Application Reference: 2025/0990

Site Address: 62 Greenfoot Lane, Old Town, Barnsley, S75 2TA

Introduction: Erection of a two storey rear extension

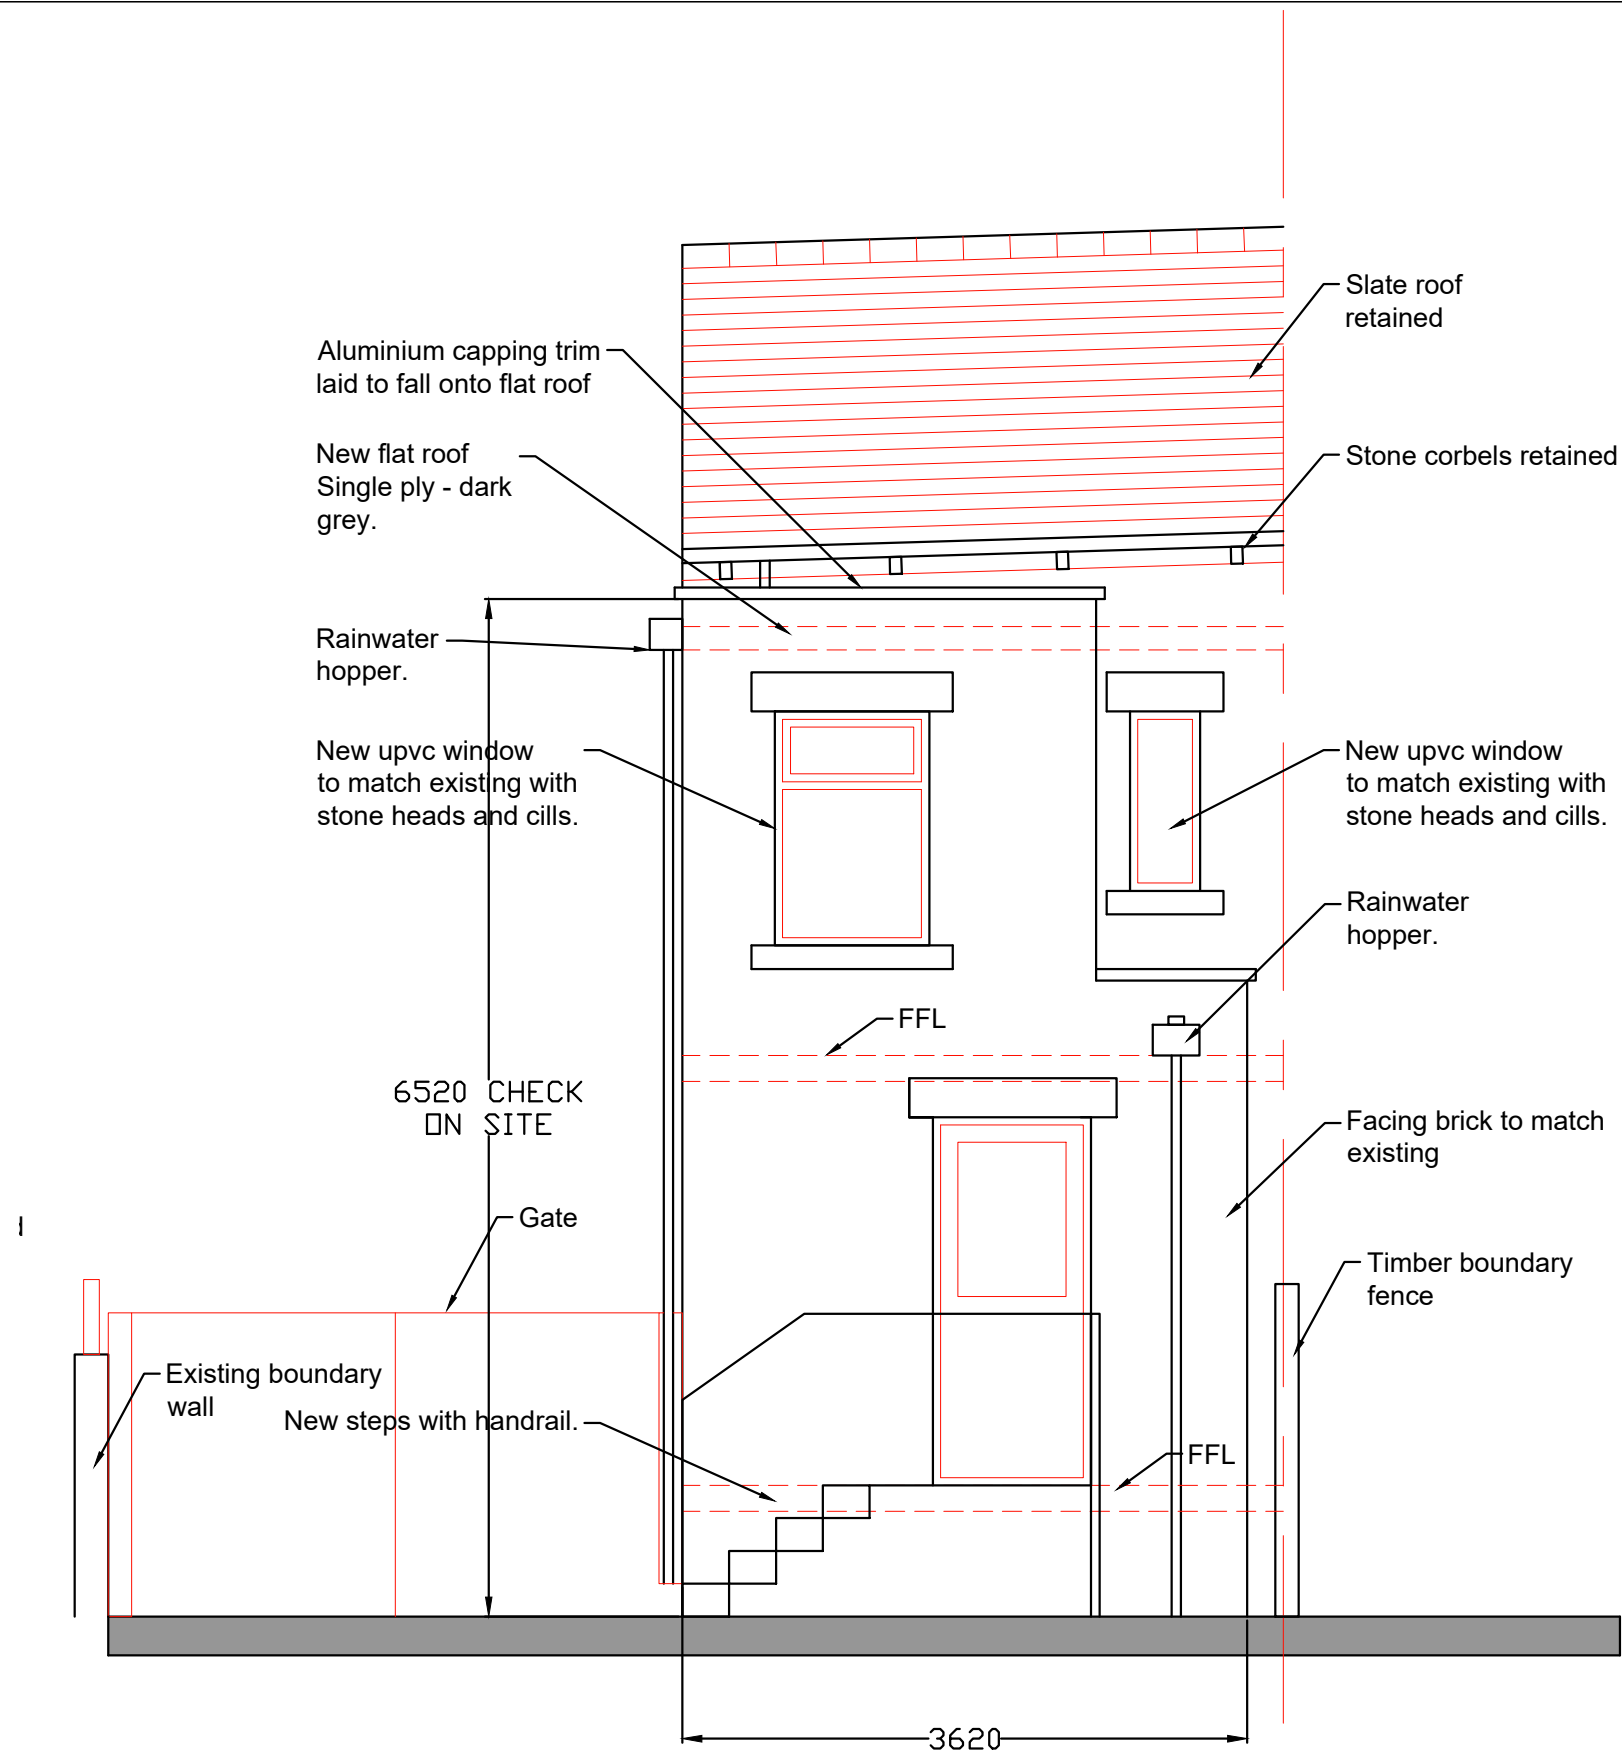
It has been necessary to make contact with the applicant to request any amendments to the proposal, however, only to amend the title of the rear elevations to 'proposed' as opposed to 'existing'. The applicant also provided amendments to the proposal to switch the initial side door and rear window to be a side window and rear door.
